Our Ref: FP/28/19/HH
Your Ref:

Town & Country Planning Act 1990 (as amended)
Town & country Planning (Development Management Procedure) (England) Order 2015
Application for Planning Permission for Works or Extension to a Dwelling

Development Proposed Side Extension
Location 12 Thirlmere Way Felpham

Block Plan shows area bounded by: 495695.92, 100487.99 495785.92, 100577.99 (at a scale of 1:500), OSGridRef: SU9574 53. The representation of a road, track or path is no evidence of a right of way. The representation of features as lines is no evidence of a property boundary.

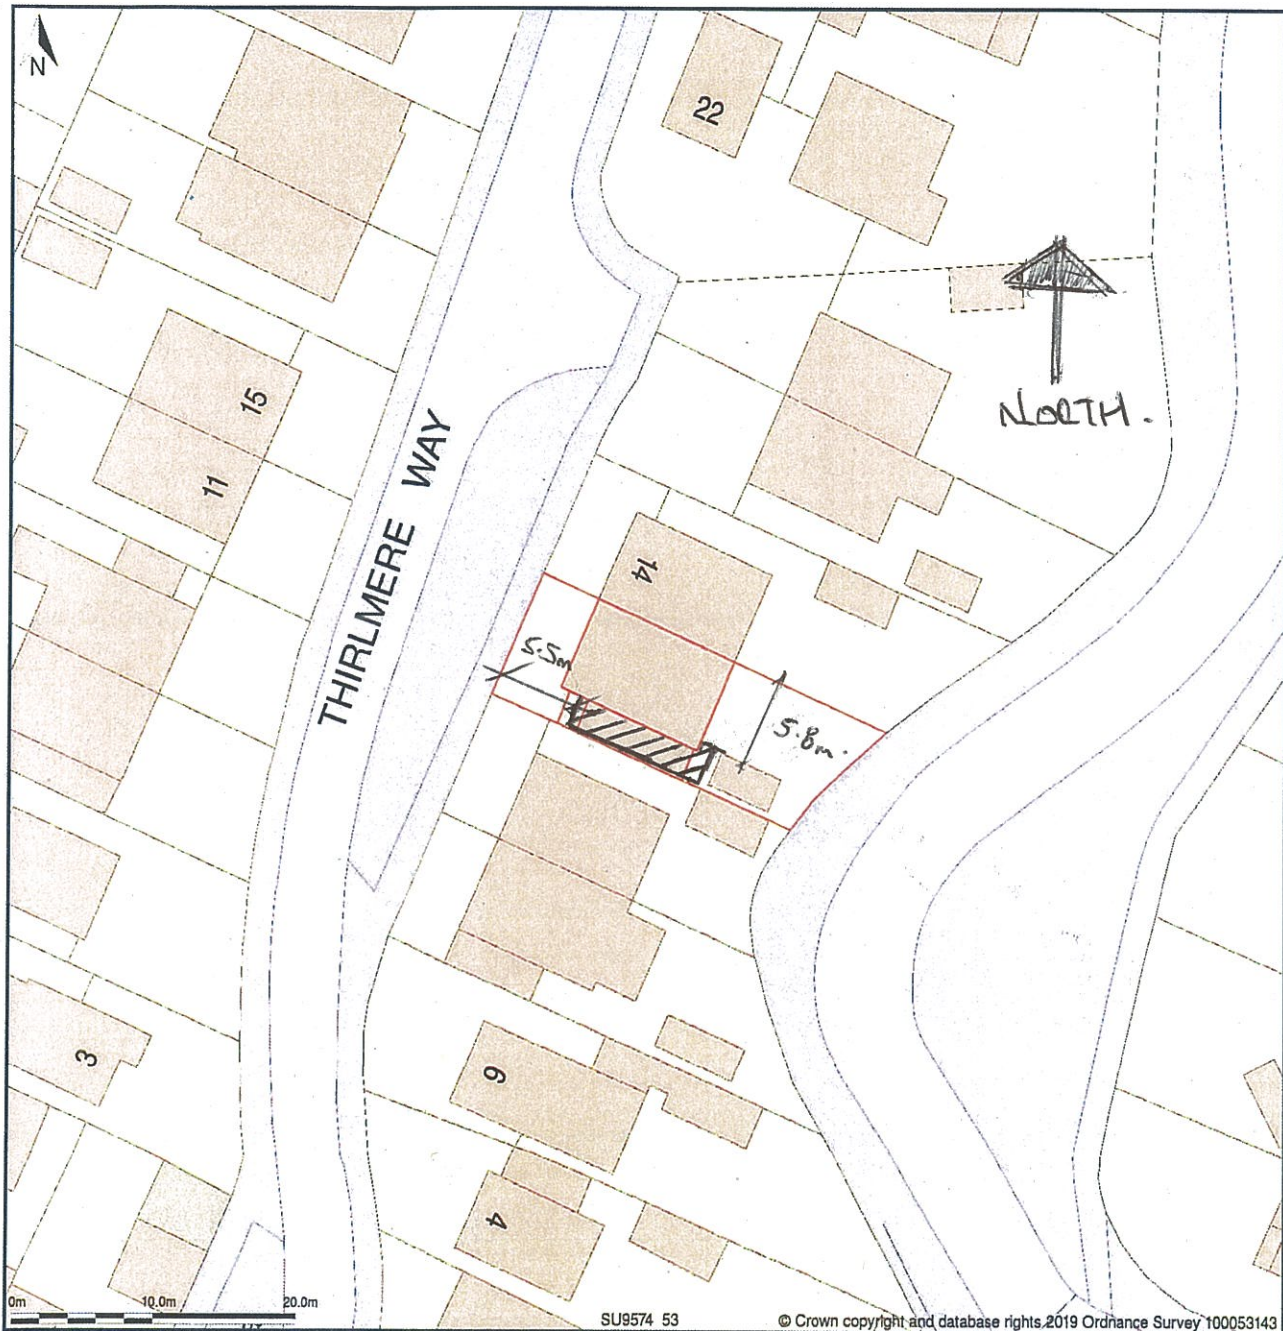
Block Plan

Please submit 1 electronic or 3 paper copies of a block/site plan at a scale of 1:500 or 1:200 which includes all dimensions from the proposal to the site boundaries. Further details of what must be included on the plan can be found in the National Validation Requirements.

Site Plan shows area bounded by: 495670.21, 100462.28 495811.63, 100603.7 (at a scale of 1:1250), OSGridRef: SU9574 53. The representation of a road, track or path is no evidence of a right of way. The representation of features as lines is no evidence of a property boundary.

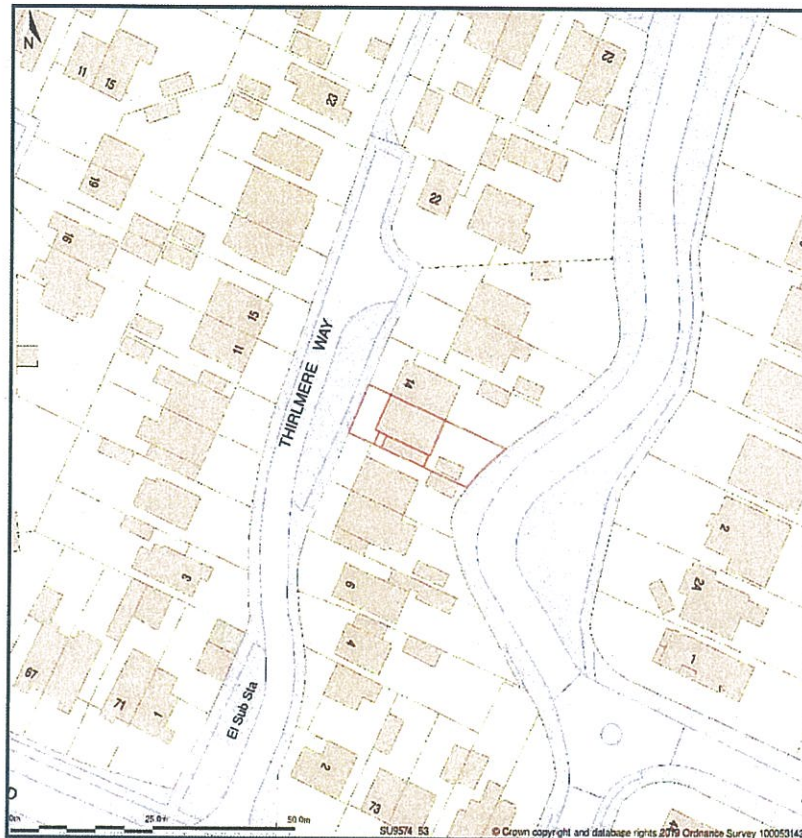
Location Plan

Please submit 1 electronic or 3 paper copies of a location plan at a scale of 1:1250 or 1:2500 for rural areas. Further details of what must be included on the plan can be found in the National Validation Requirements.

ELEVATIONS AS PROPOSED.
[1:100]

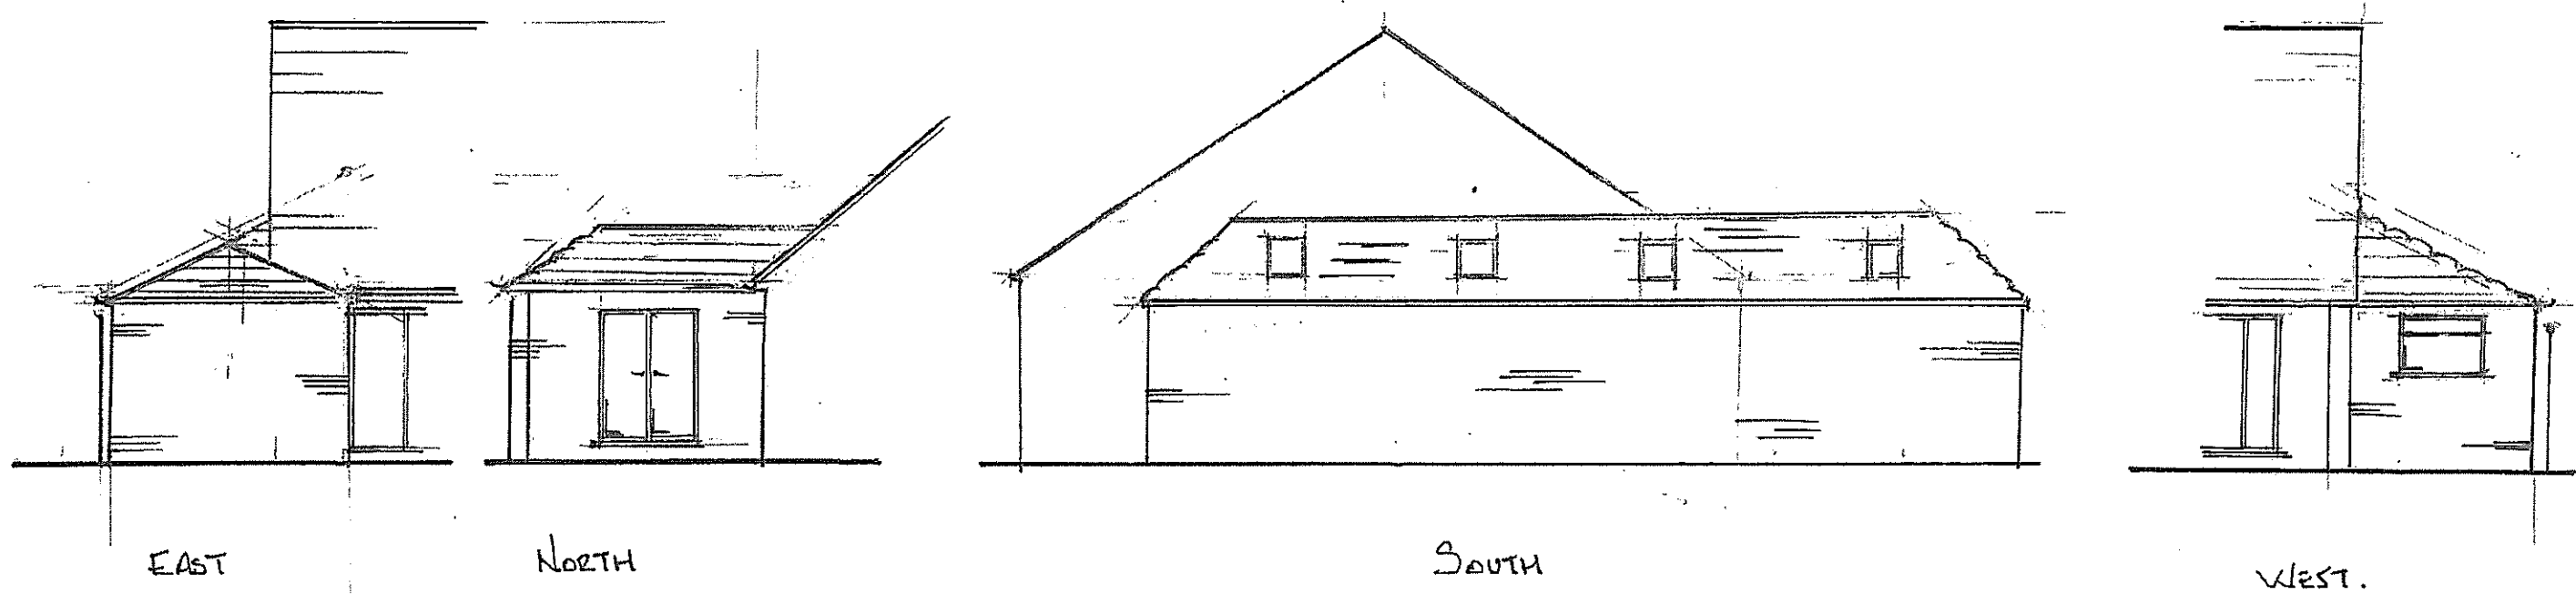
Scale: You are required to have a scale on all plans. Currently the proposed elevations do not have a scale please review and amend accordingly.
